Appeal Decision

Appeal Ref: APP/R5510/D/24/3341943

44 Warren Road, Ickenham UB10 8AD

- The appeal is made under section 78 of the Town and Country Planning Act 1990 (as amended) against a refusal to grant planning permission.
- The appeal is made by Mr M Ali against the decision of the Council of the London Borough of Hillingdon.
- The application Ref. is 17392/APP/2024/121.
- The development proposed is a single storey rear conservatory.

PROPOSED REAR ELEVATION

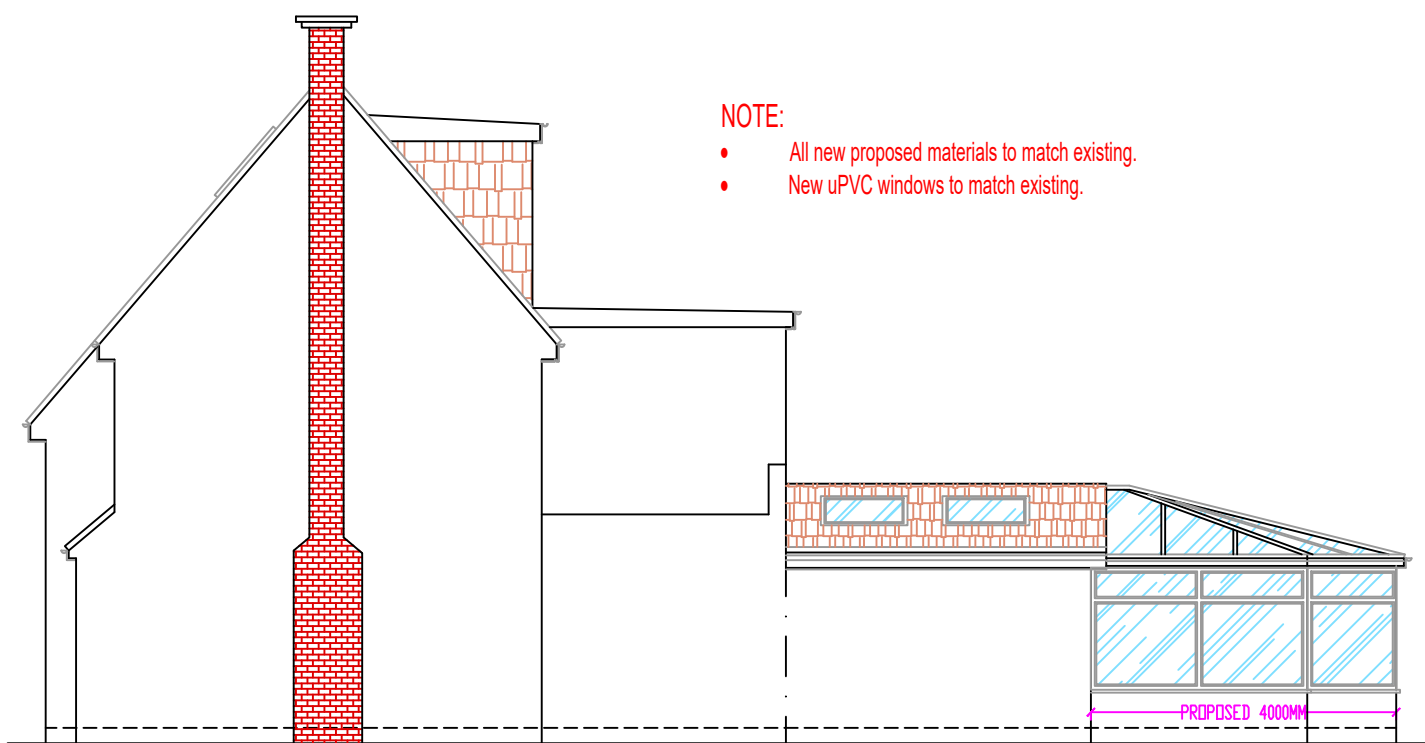
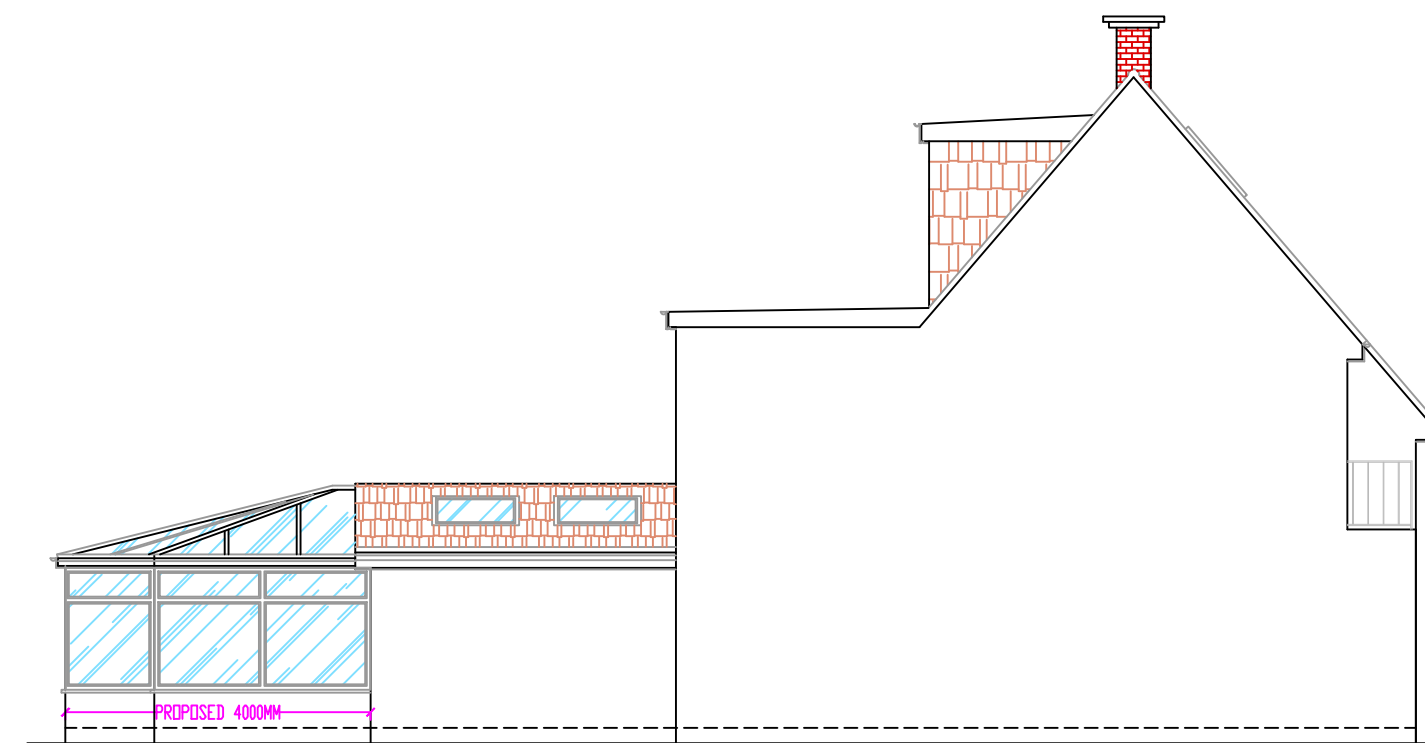
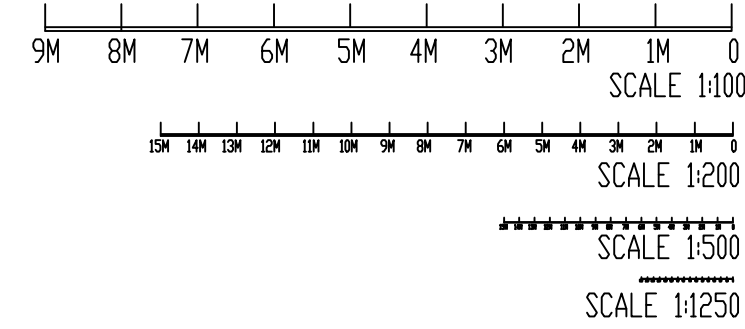
5. The proposed conservatory extension would be about 4m deep, about 7m wide with a maximum height of about 3.4m and an eaves height of about 2.4m. It would be set in from both sides of the existing single storey rear extension. It would be made from contemporary materials and would appear lightweight in nature.

6. It would add additional mass and bulk to the rear of the appeal property and cumulatively the depth of extensions at the rear would be about 8m from the main rear wall. However, it would not exceed the height of the single storey rear extension and it would be narrower, so that there would be a graduation of widths the further into the garden that built development protruded. It would also be slightly rounded rather than have right angle corners.

7. It would sit on a low plinth wall but otherwise the minimalist metal frame, transparent sides and roof would enable it to appear lightweight in appearance. As a result, it would not dominate the character of the rear elevation despite the individual or cumulative depth and despite its exceedance of prescribed measurements in policy DMHD 1 of the Hillingdon Local Plan: Part 2 - Development Management Policies (2020). Overall, extensions that have taken place at the rear plus the proposed conservatory would be subordinate to the original dwelling. The area of rear garden remaining free of built development would be sufficiently large to provide useable private outdoor amenity space for the occupants of the dwelling.

9. I have considered whether the proposed development taken alone or cumulatively with recent rear extension would lead to a loss of outlook, sense of enclosure or be visually intrusive for occupants of nos 42 and 46 Warren Road. Whilst it may be possible for those occupants to glimpse the conservatory roof, it would not be unduly close to either of the common boundaries. In relation to no.42, the conservatory would be closest to its common boundary with the appeal site, but the separation distance would be such as to rule out any sense of enclosure. The boundary treatment includes fencing which is of a height providing effective screening. The separation distances from the common boundary with 46 are more generous and, again, would prevent any feeling of enclosure to the occupants of 46 when in their rear garden.

WARREN ROAD
PROPOSED SITE PLAN
SCALE 1:200@A1

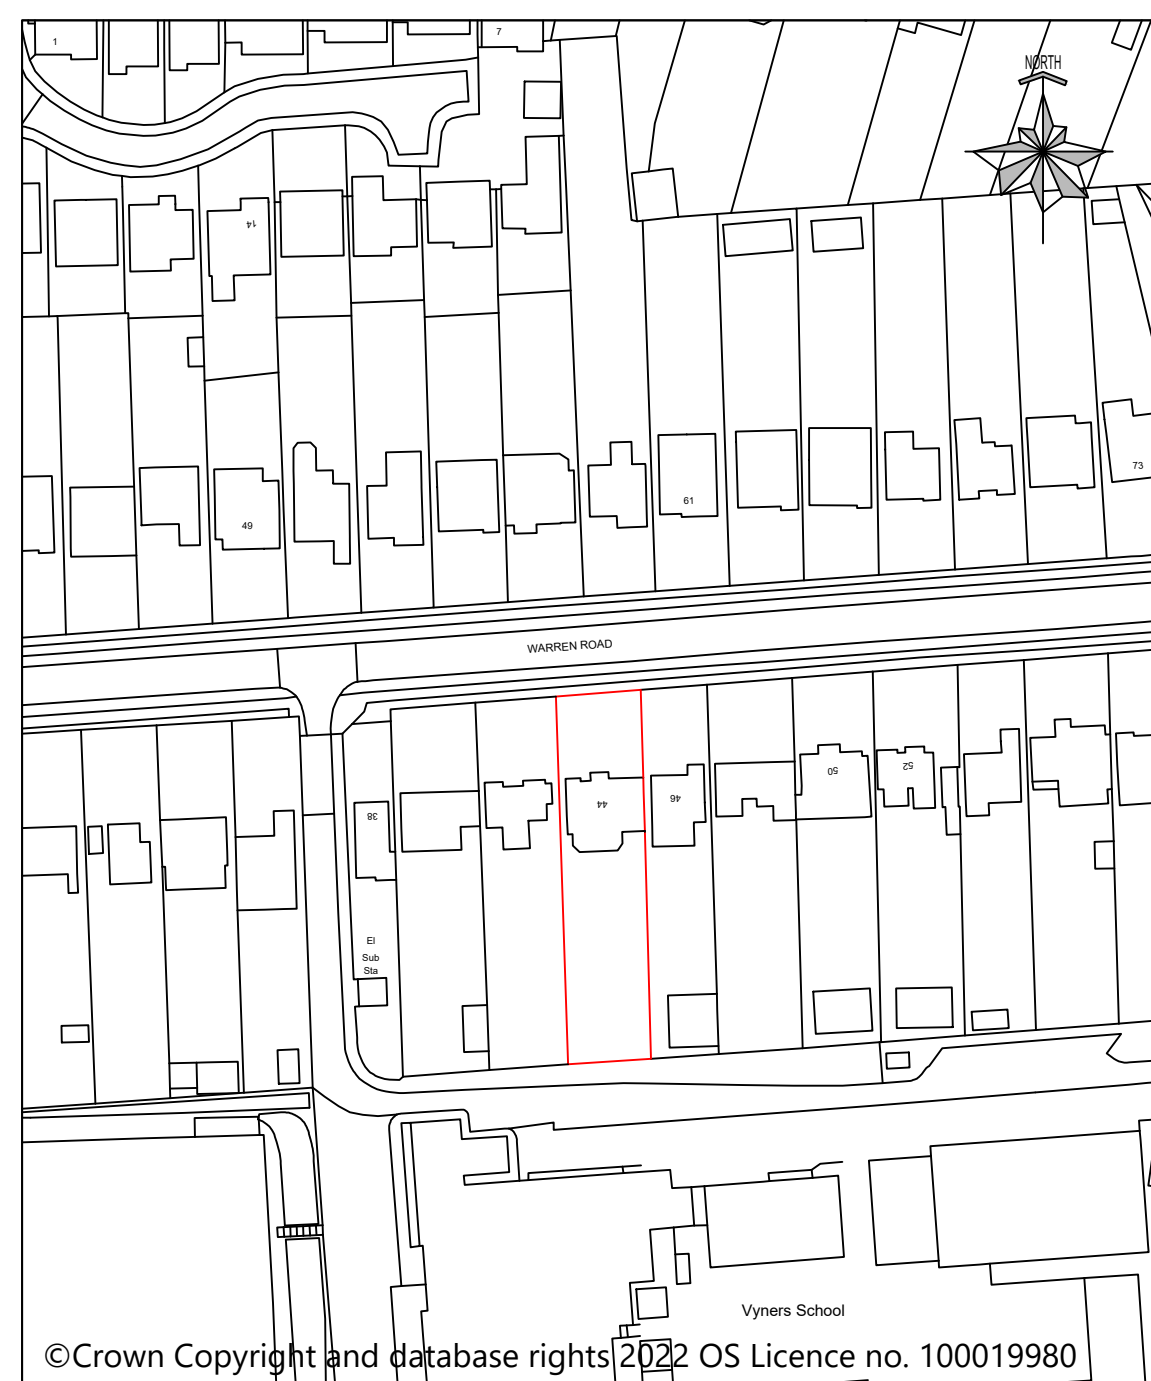
10. In respect of potential loss of light, the siting of the proposed conservatory would not materially block daylight or sunlight from the rear garden or rear windows of either no.42 or no.46. This would also be the case when assessed cumulatively with the existing rear extension. As to visual amenity for neighbours, there is no right to a view from a window or a garden. This is distinguishable from loss of outlook or undue enclosure where a new extension might be of such proximity and dimensions so as to be oppressive to a neighbour. I have not found there to be a loss of outlook as a result of the proposal and I have given reasons for this above. The neighbours would see the conservatory and parts of the rear extensions from upper floor rear windows but it would not harm their residential amenity.
